**616-618 Congress Street ~ Lazzari LLC ~ Building Permit ID: 2015-01687**

This is to let you know that 1 of 2 urinals has been deleted from the street floor Men's lavatory (see drawing A-1) for restaurant patrons due to impracticability of installation and clearances.

DRAWN BY: ###
 DATE: 12/22/2015
 A-1.1

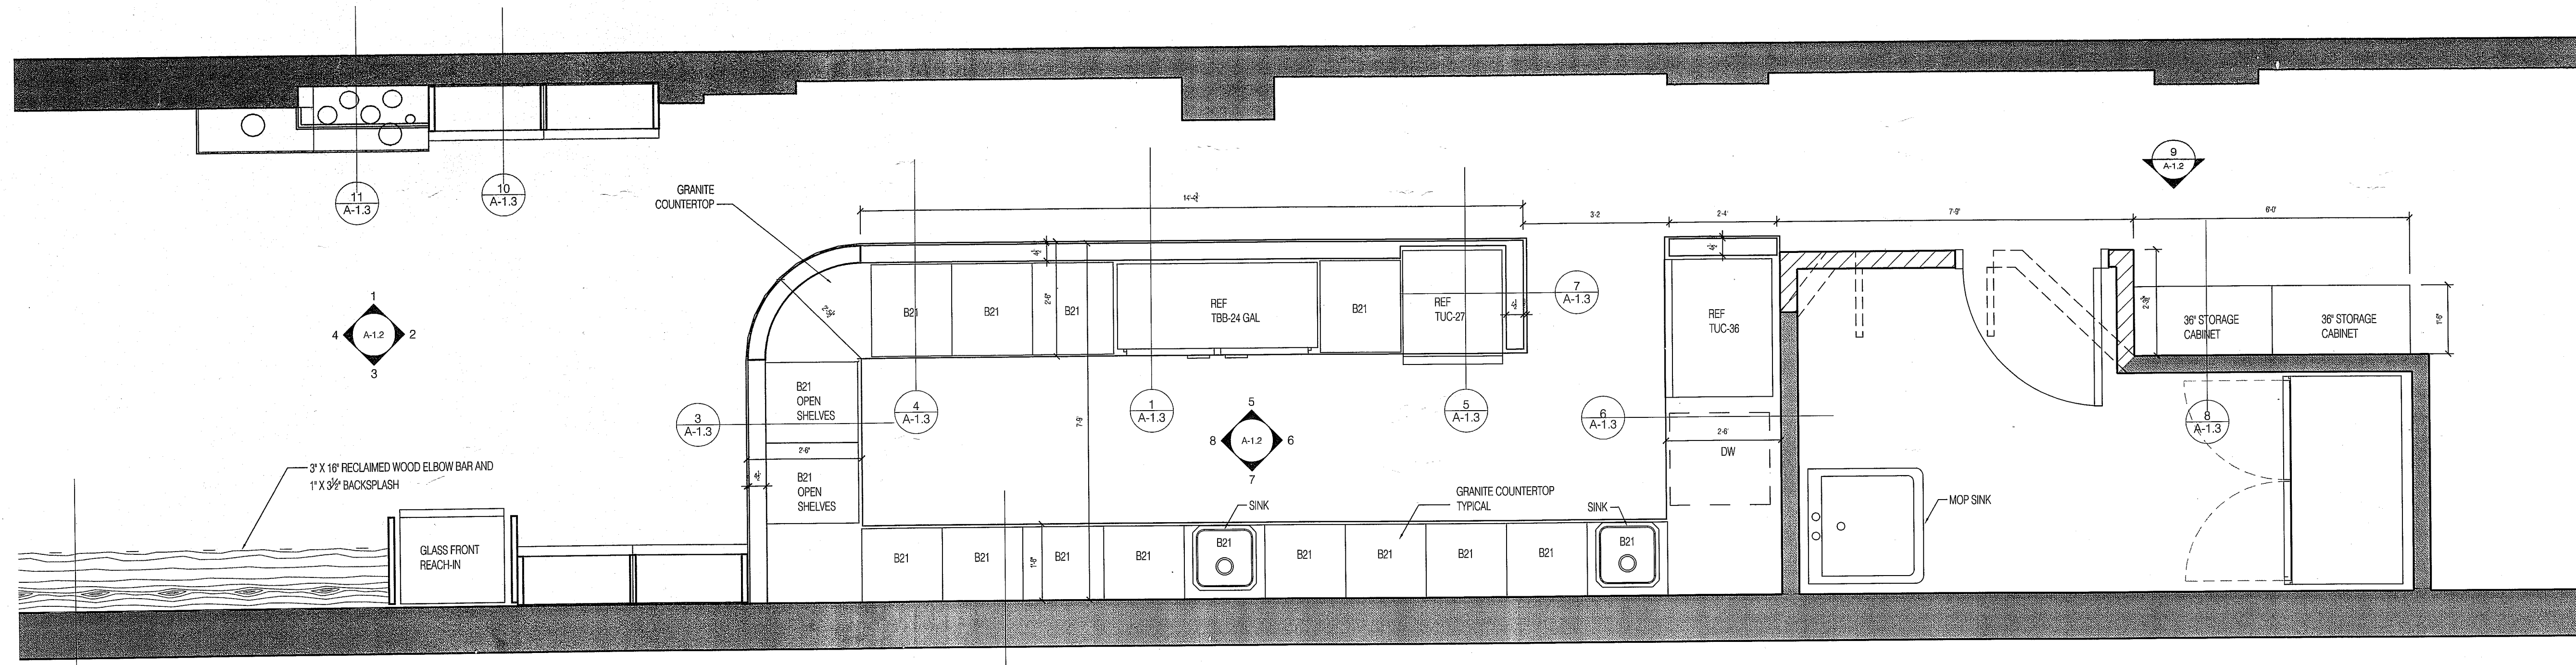
I have reviewed the Uniform Plumbing Code 2009 Table 4-1 Minimum Plumbing Facilities "Restaurants, pubs and lounges" and find that the fixture/occupancy requirement is met with one urinal given the restaurant seating load of 88-90 we have projected.

I reviewed the approved plans to confirm the number of fixtures in the men's bathroom and see that the proposed change will reduce the urinals to 1. With this and the 1 WC this will comply with the UPC requirements.

I will file this email with the permit documents memorializing the removal on 1 urinal from the men's bathroom.
